Application No: AB/11/22/CLP

Site Address: 8 Mount Pleasant Arundel BN18 9BD

Description of works: Lawful development certificate for proposed:

Thank you for your internet representation made on 7th March 2022 which has been recorded as an objection with the comments as follows:

Drawing	Scale
PROPOSED ELEVATIONS	1:100 @A3

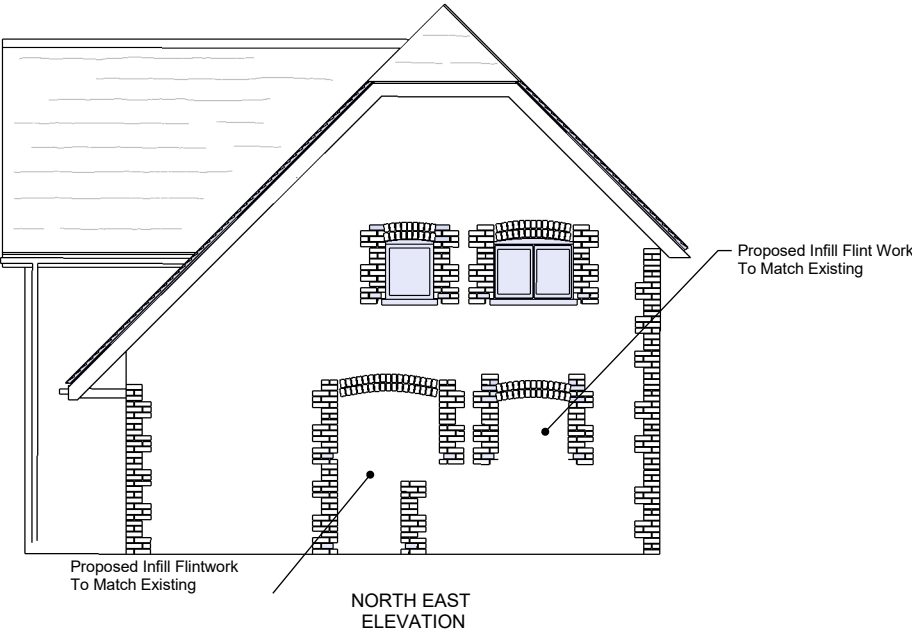
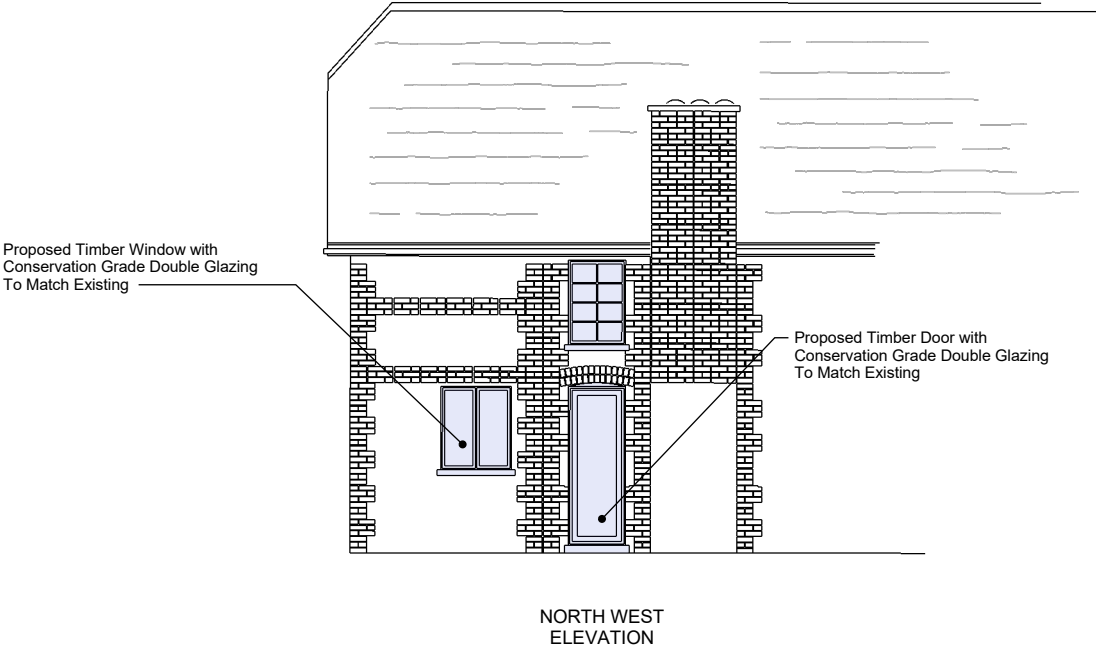
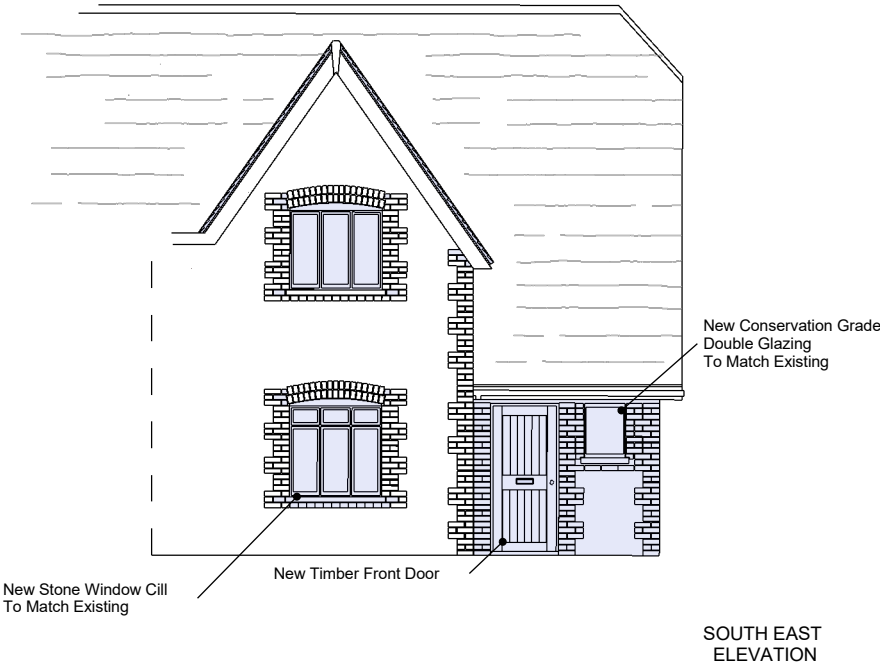
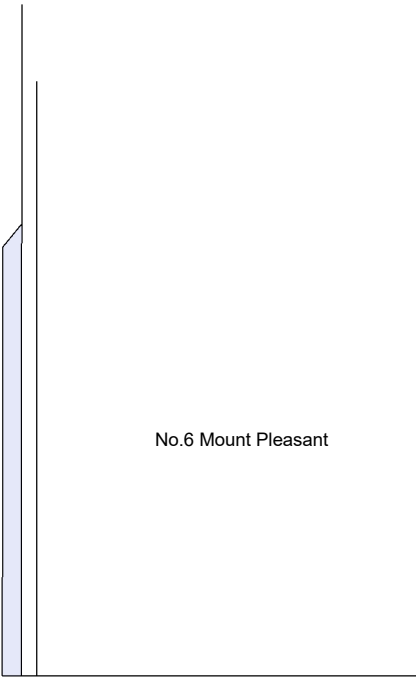
The Committee objected to the Application based on the lack of information provided, showing that the replacement double glazed windows would cause harm to the designated Conservation Area in conflict with HER DM1*** and HER DM3* of the Arun Local Plan and the National Planning Policy Framework. It is believed that this should be submitted as a full planning application as we have concerns to implications in the Arundel Village Design Statement.
